Section 73 of the Town and Country Planning Act 1990

Application to Vary Planning Permission Ref: 2025/62/91965/E

Site: Land at Gelderd Road, Birstall, Batley, WF17 9LS

On behalf of our client, Tesla Motors Ltd, we hereby submit an application under Section 73 of the Town and Country Planning Act 1990 to vary Conditions 2, 9, 15, 17, 18 and remove Condition 16 attached to planning permission ref. 2025/62/91965/E for the installation of electric vehicle charging infrastructure at land off Gelderd Road, Birstall, Batley WF17 9LS.

DWG No. CRM3030020-ENZ-XX-XX-DR-Z-0001	Revision PL02
--	-------------------------

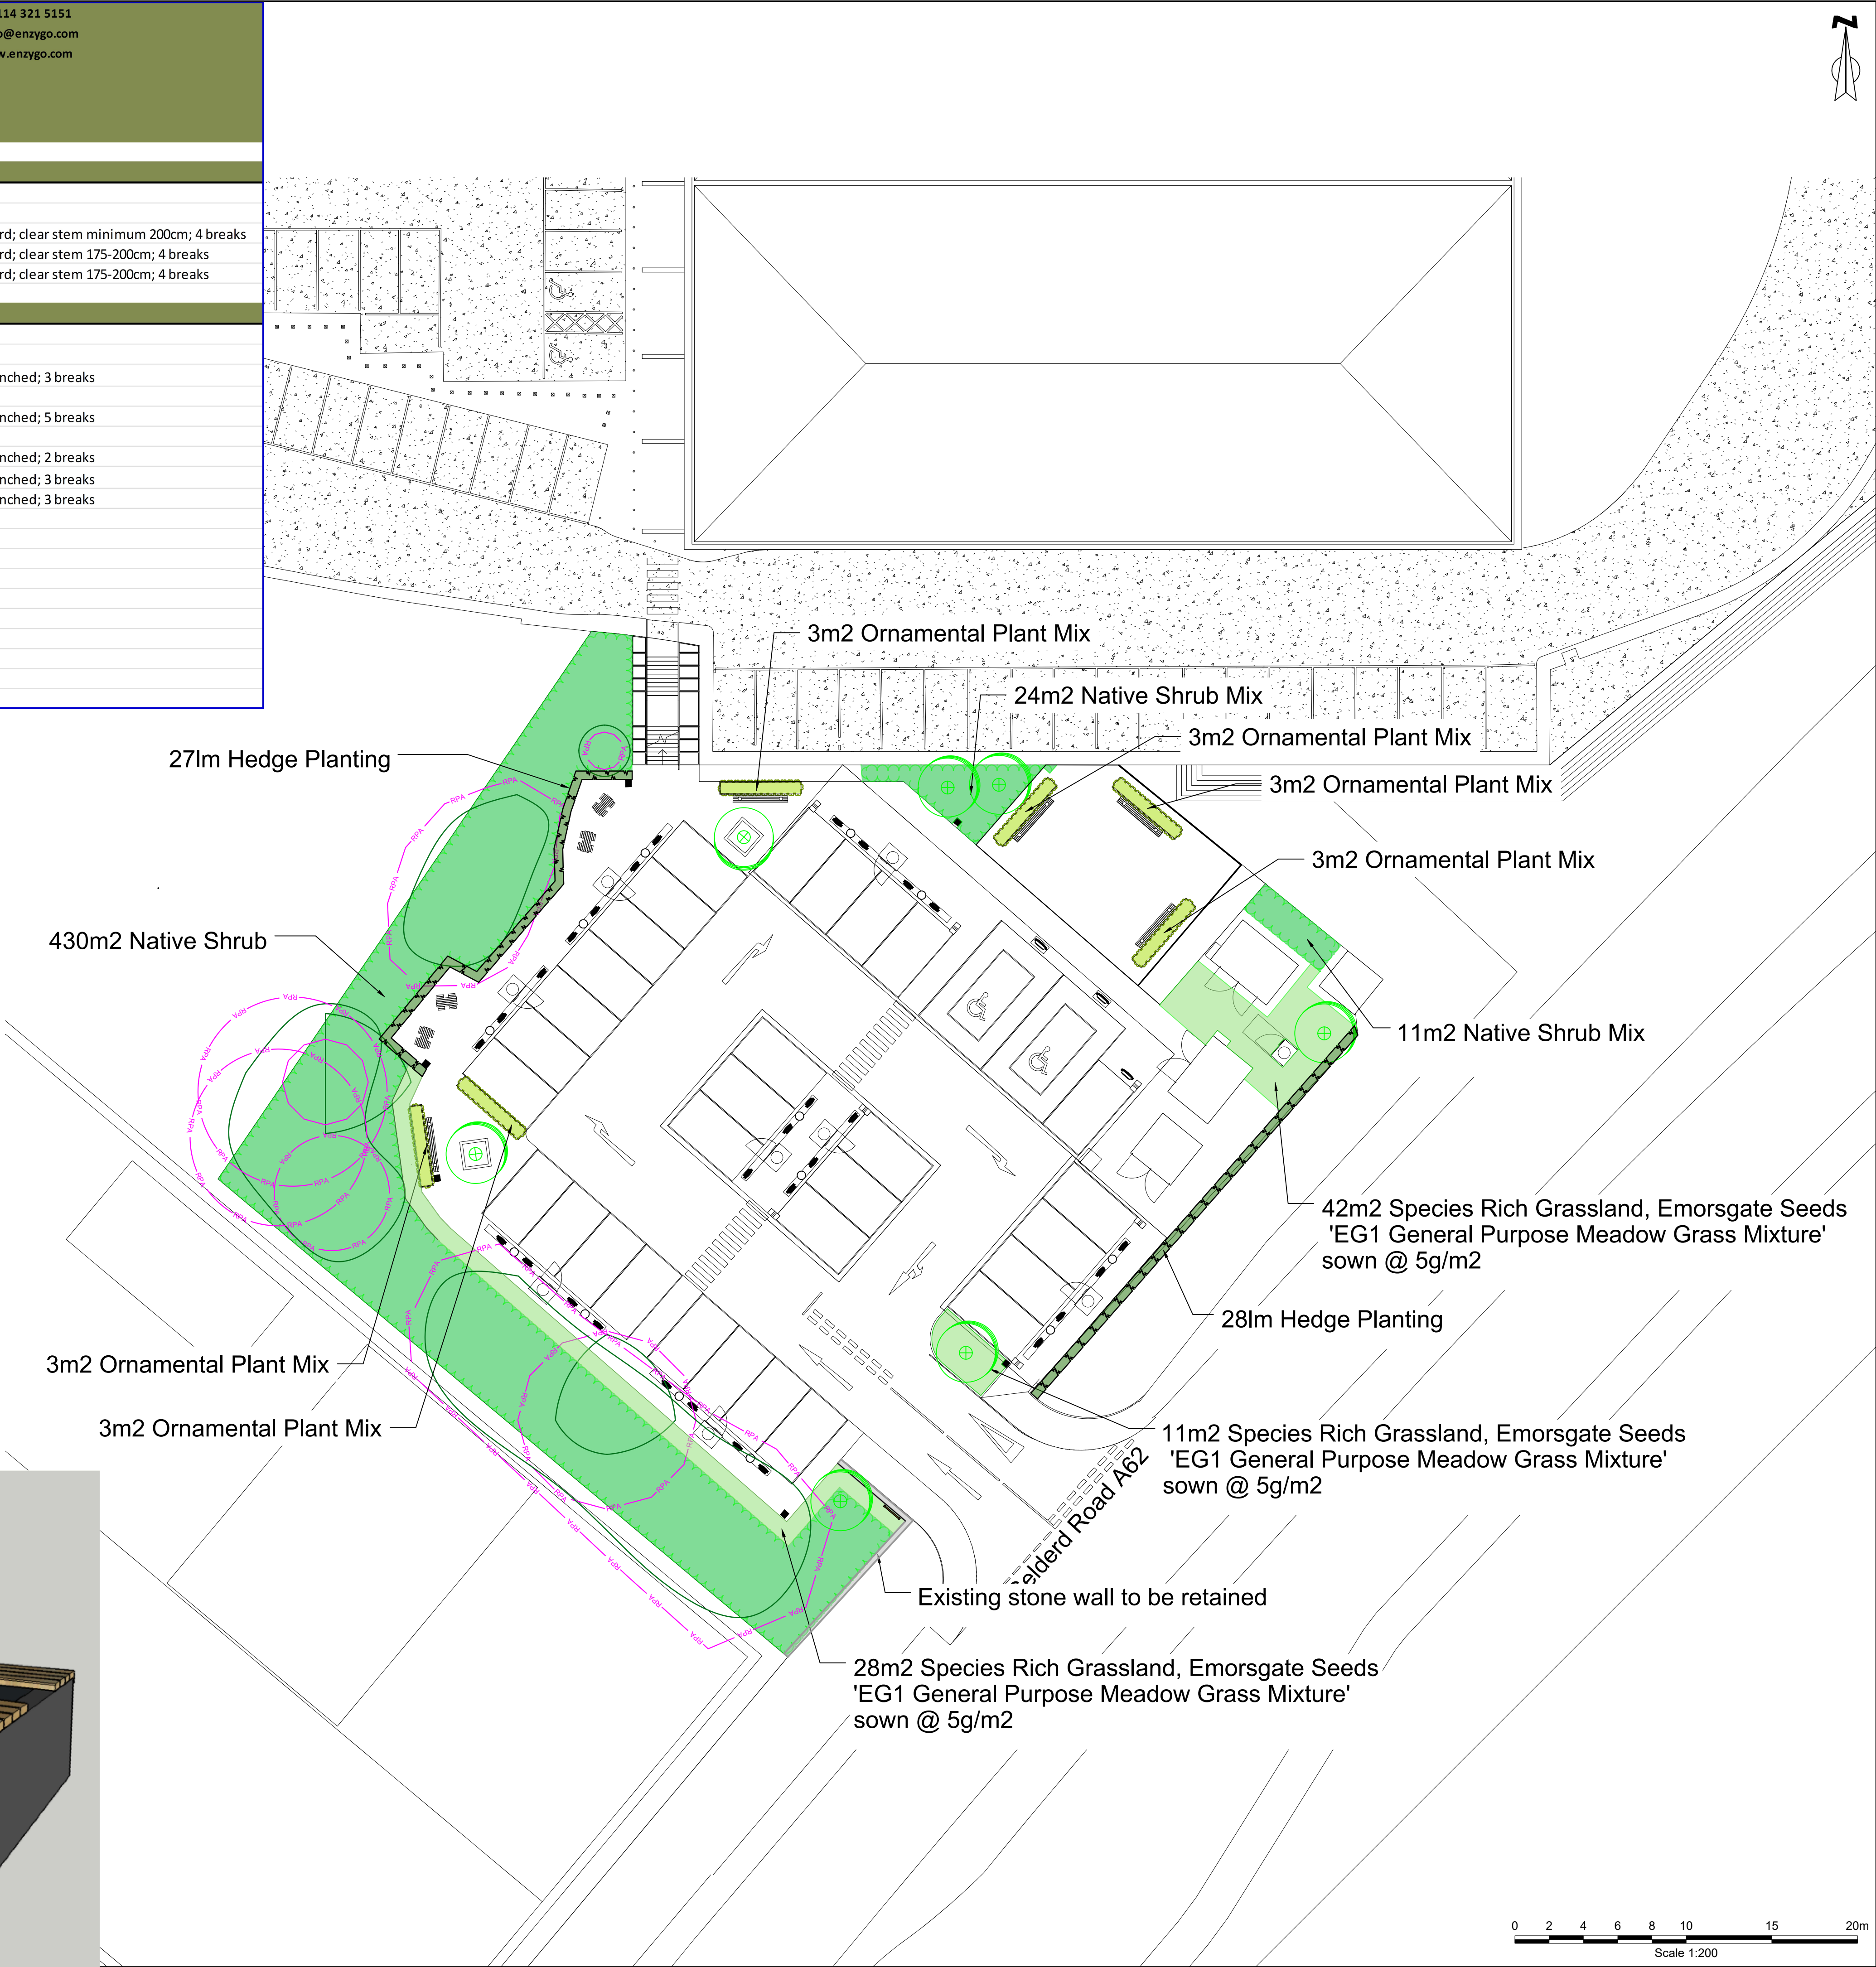
- **Vary Condition 15** - to update the approved soft landscaping scheme to reflect the amended site layout.
- **Remove Condition 16** - to remove the requirement for the CCTV scheme as it relates to the amenity block, which is no longer proposed.

It is proposed to vary Condition 15 to update the approved landscaping reference to reflect the revised site layout following the removal of the amenity block. The overall landscaping strategy, quantum of planting and biodiversity benefits remain consistent with the approved scheme.

"The approved landscaping scheme shown on drawing no. CRM3030020-ENZ-XX-XX-DR-Z-0001 PL02 shall be implemented by the end of the first planting season following the development being brought into use. The approved landscaping scheme shall, from its completion, be retained throughout the lifetime of the development. If, within this period, any tree, shrub or hedge shall die, become diseased or be removed, it shall be replaced with others of similar size and species unless the Local Planning Authority gives its written consent to any variation. All soft landscaping shall be retained as soft landscaping for the lifetime of the development."

Proposed Site Plan

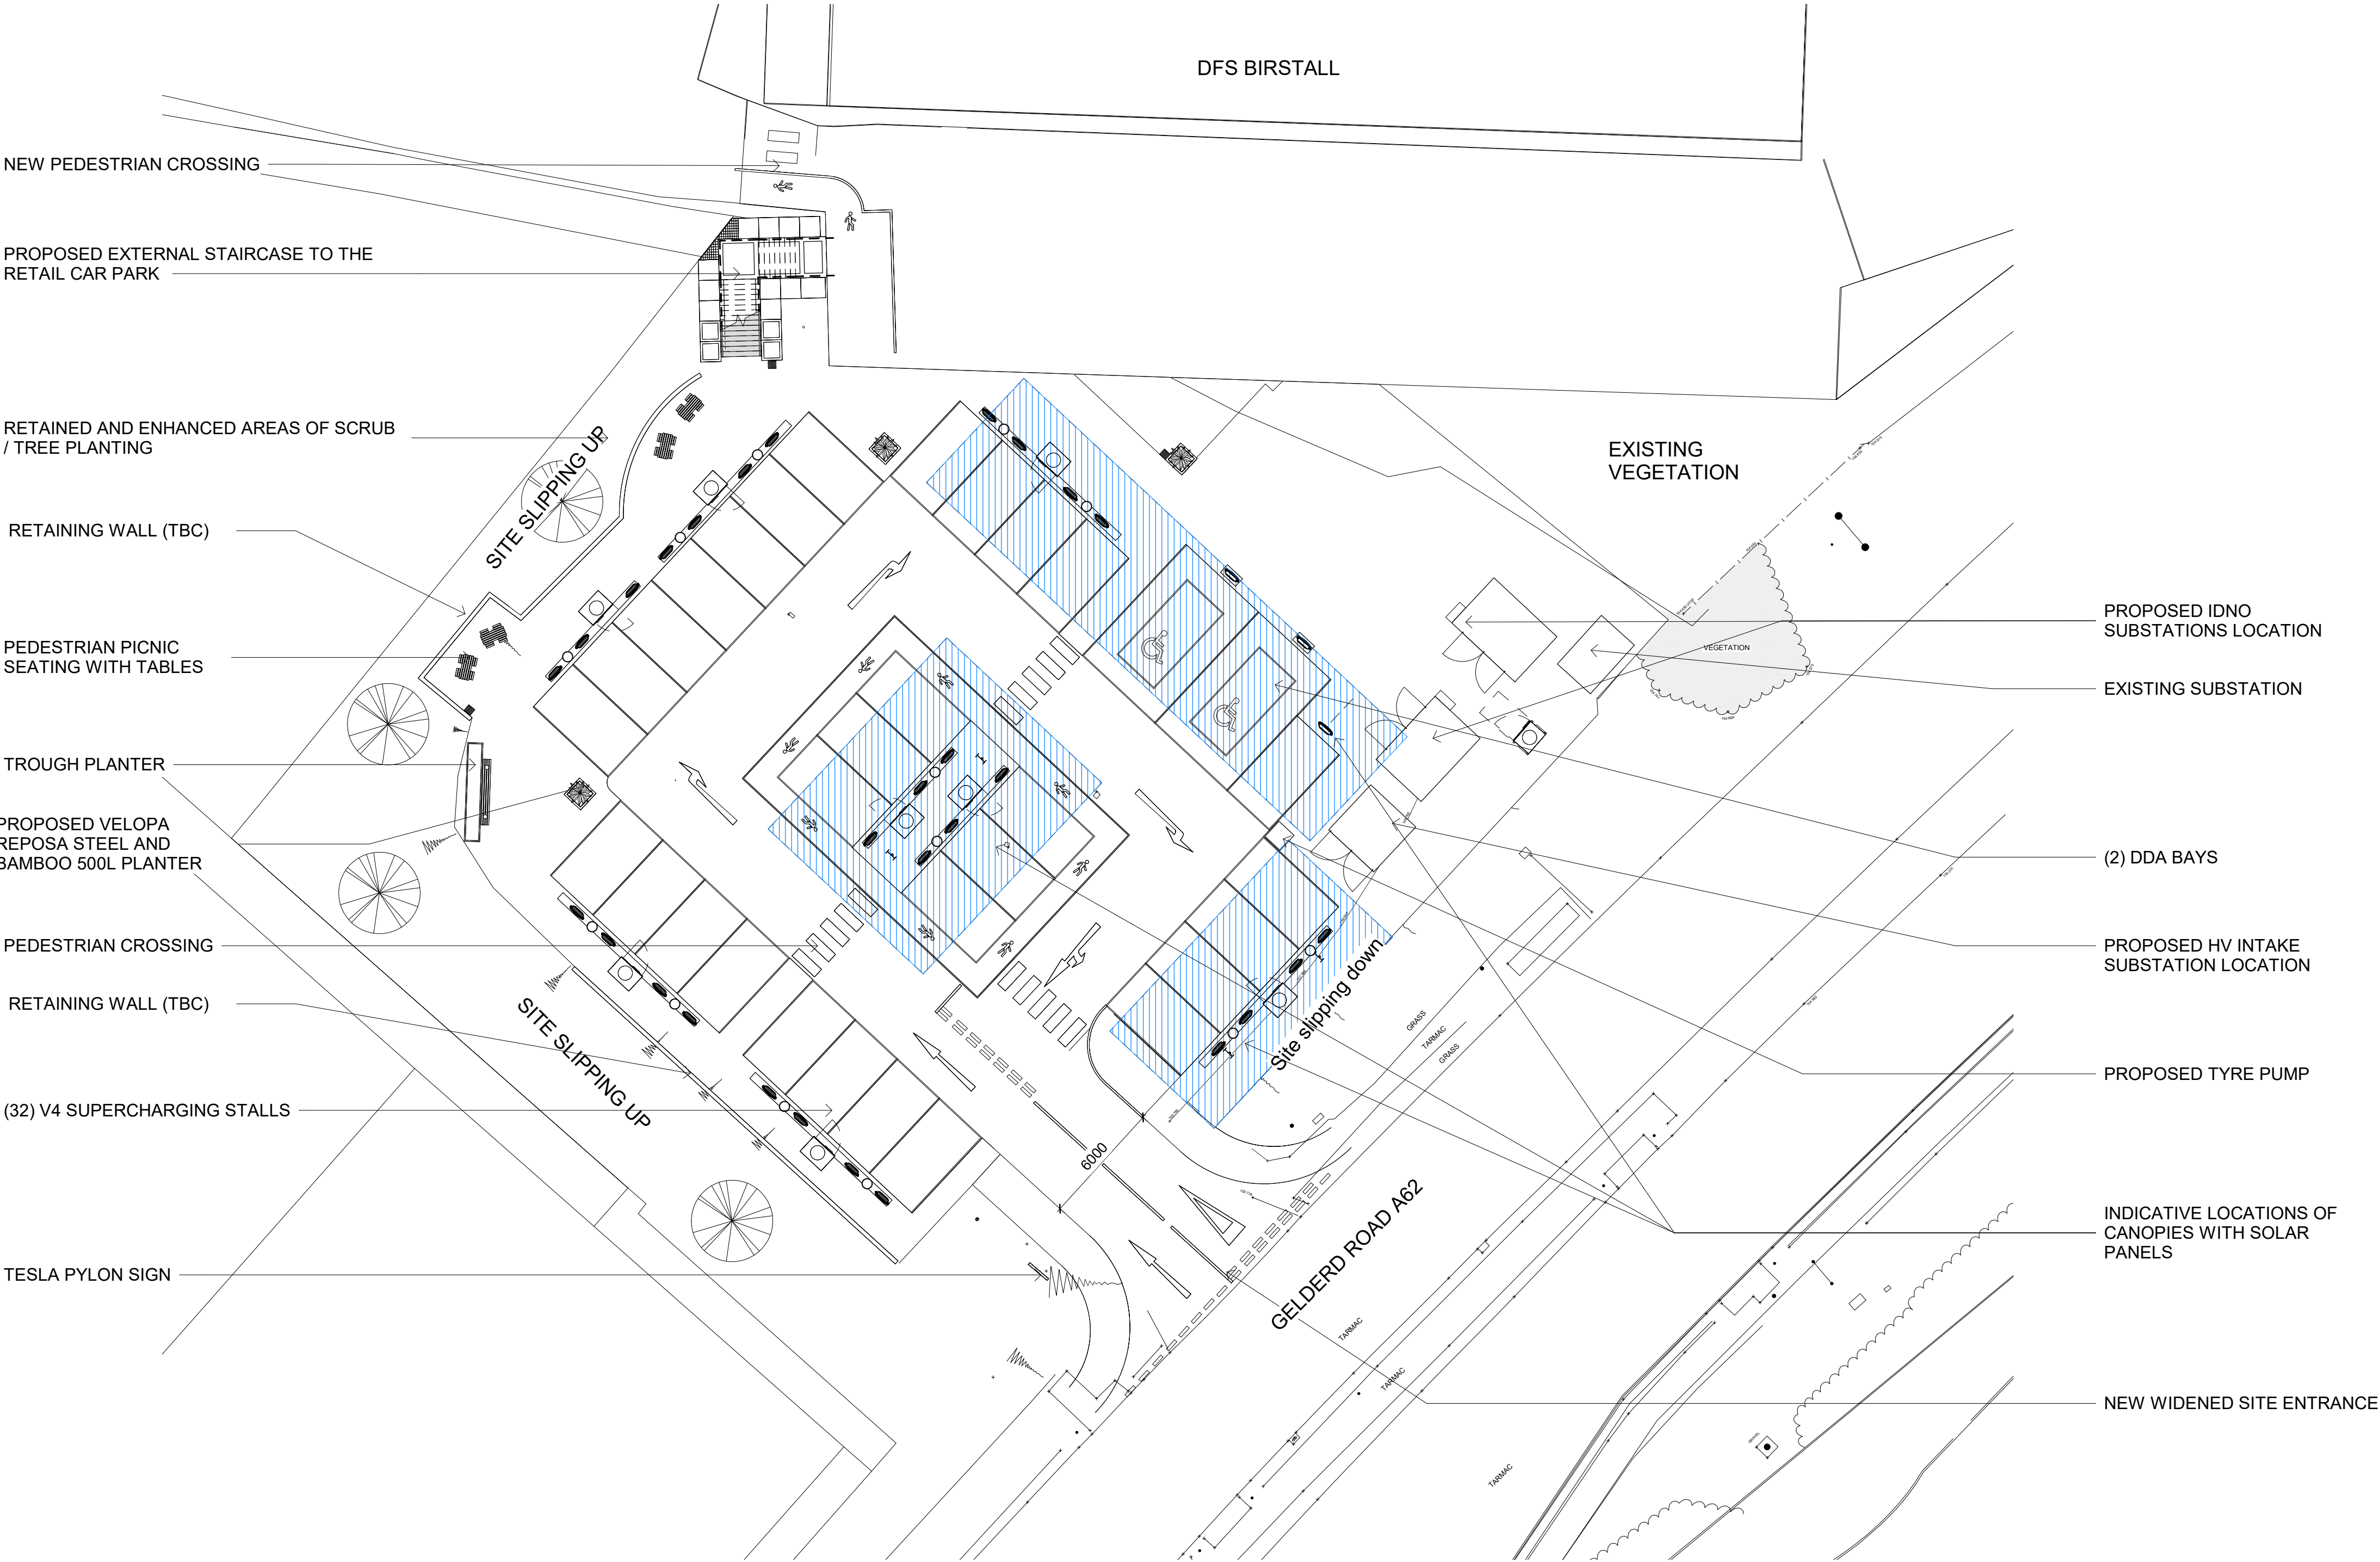
Since the grant of permission, the scheme has been reviewed by the operator and it has been determined that the amenity block is no longer required to support the operation of the charging hub.

The principal change is the orientation of the upper landing and exit point onto the retail park. Following a detailed review of pedestrian movement patterns, the staircase has been amended to provide a more intuitive and logical point of arrival within the retail park. The revised arrangement allows users to enter the site via a dedicated landing area before continuing their onward journey, creating a clearer and more legible pedestrian route that better reflects the natural desire lines and movement of visitors through the site.

The Section 73 application therefore seeks to remove the amenity block from the approved plans, with all other elements of the development remaining unchanged in principle.

- **Vary Condition 2** - to allow the development to be carried out in accordance with revised approved plans which omit the amenity block and amend the staircase;

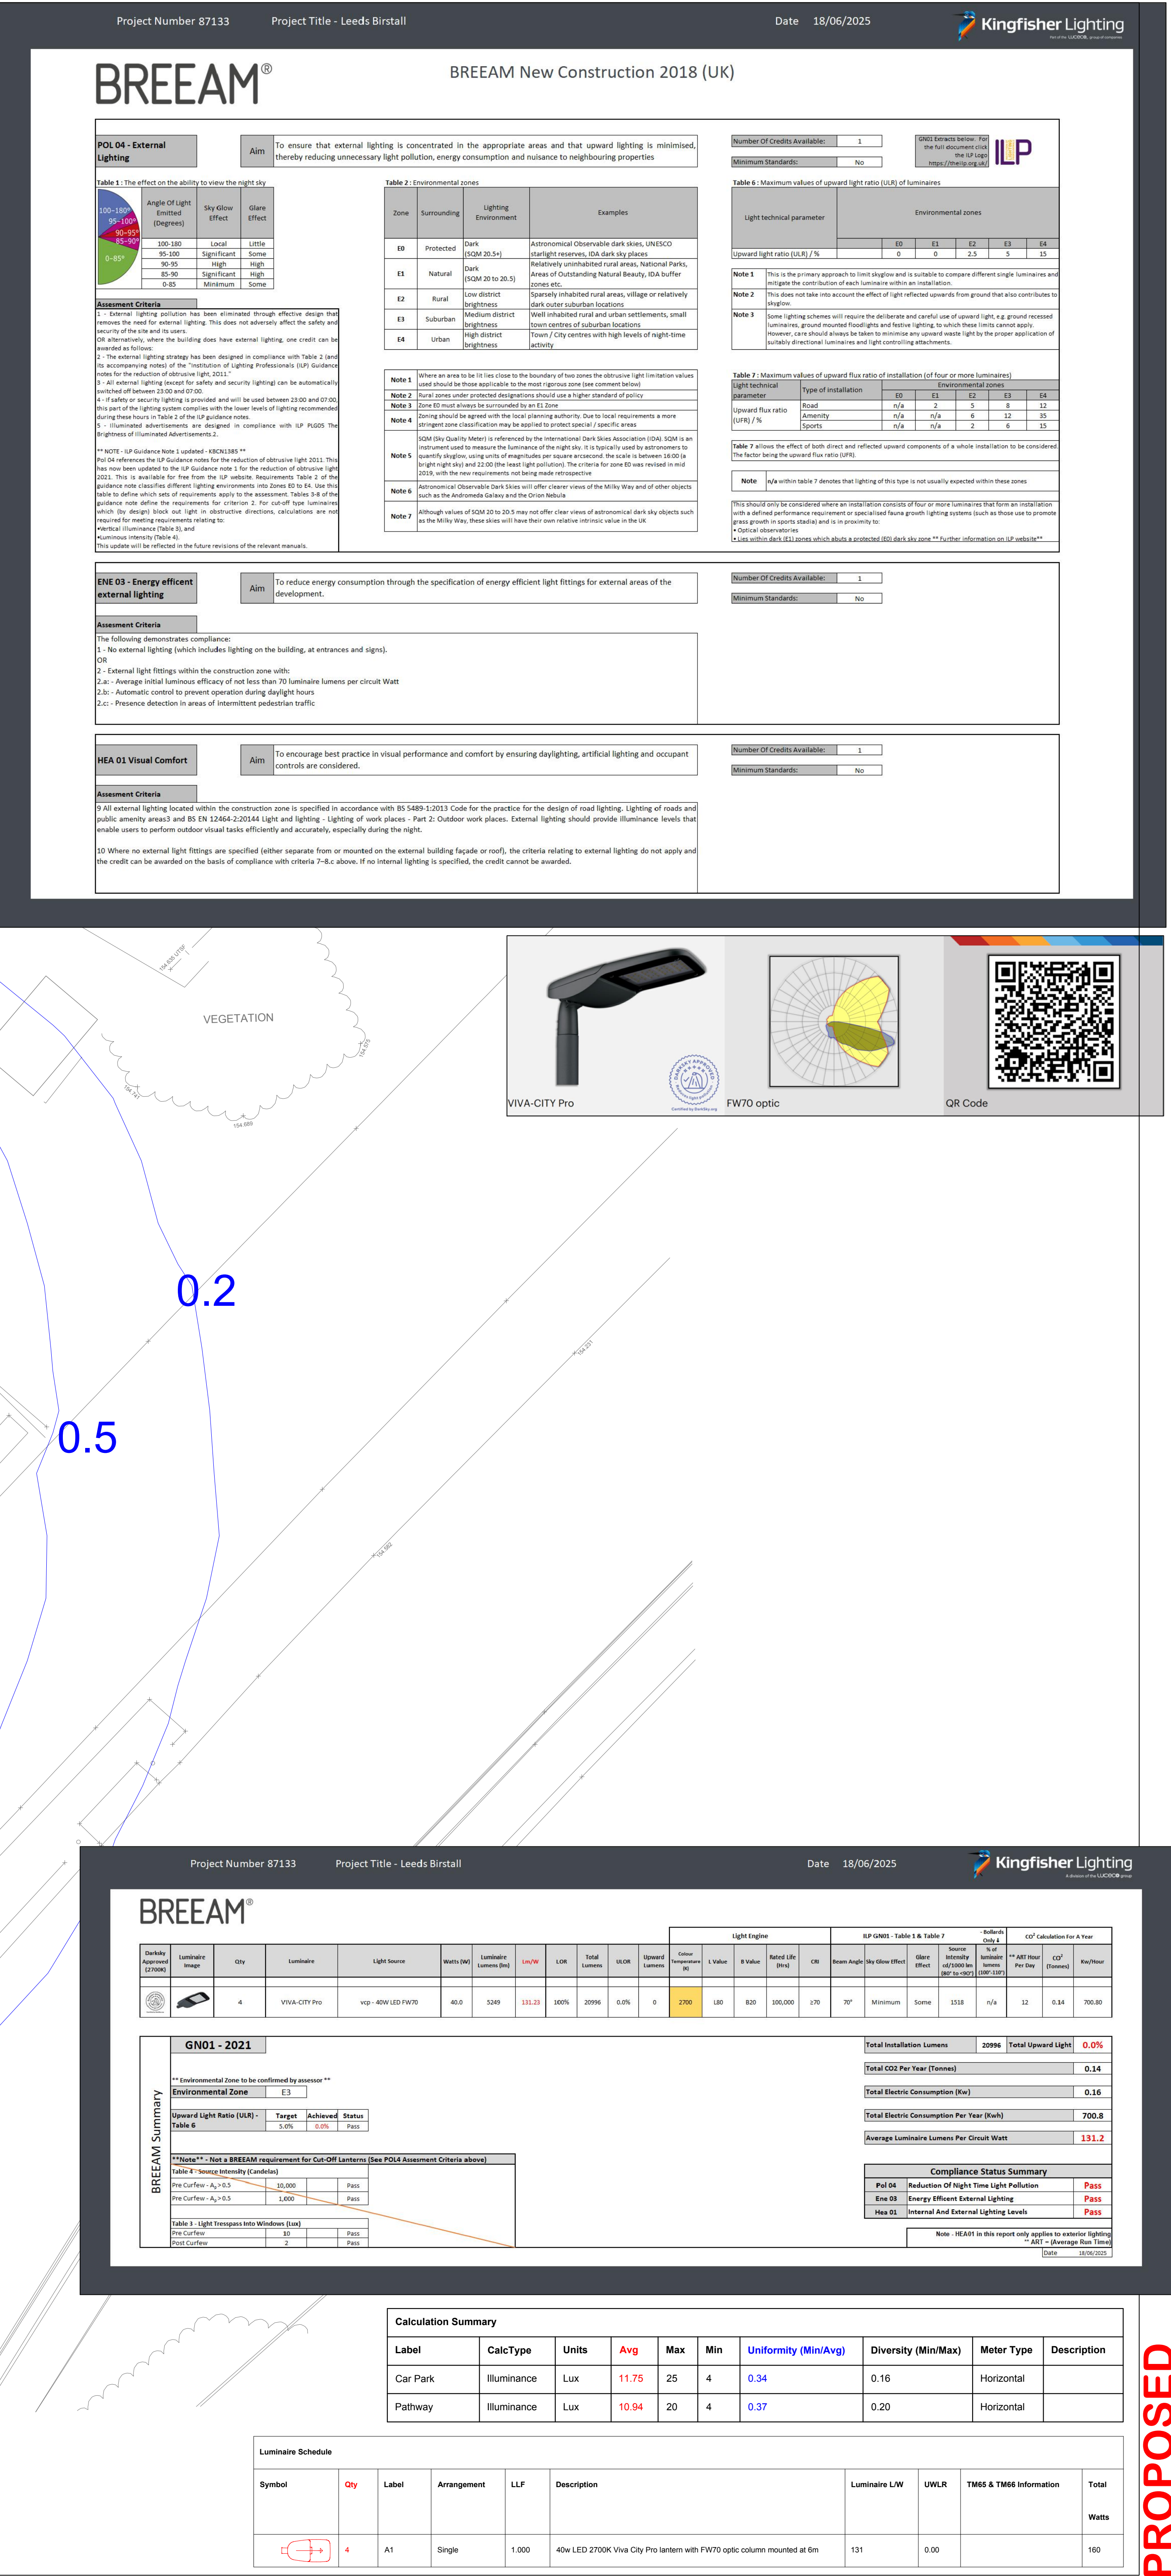
- **Vary Condition 17** - to amend the approved lighting scheme to reflect the revised layout.
- **Vary Condition 18** - to remove references to the amenity block from the requirement for approval of external materials. Material details for substations, staircase and solar canopy submitted to amend this condition to a compliance condition.

It is proposed to vary Condition 17 to update the approved lighting reference to reflect the revised site layout following the removal of the amenity block. The revised lighting scheme continues to control light spill, glare and column heights in accordance with the originally approved principles.

“The lighting scheme as detailed on drawing no. 0075 - CSE - ZZ - XX - DR - E - 6302 - S1 - P02 shall be installed in accordance with the light spill and stray light levels indicated on the approved plan. All lighting shall be downward facing and mounted on lighting columns which shall not exceed a height of 6.0 metres. The lighting scheme shall thereafter be retained and maintained for the lifetime of the development.”
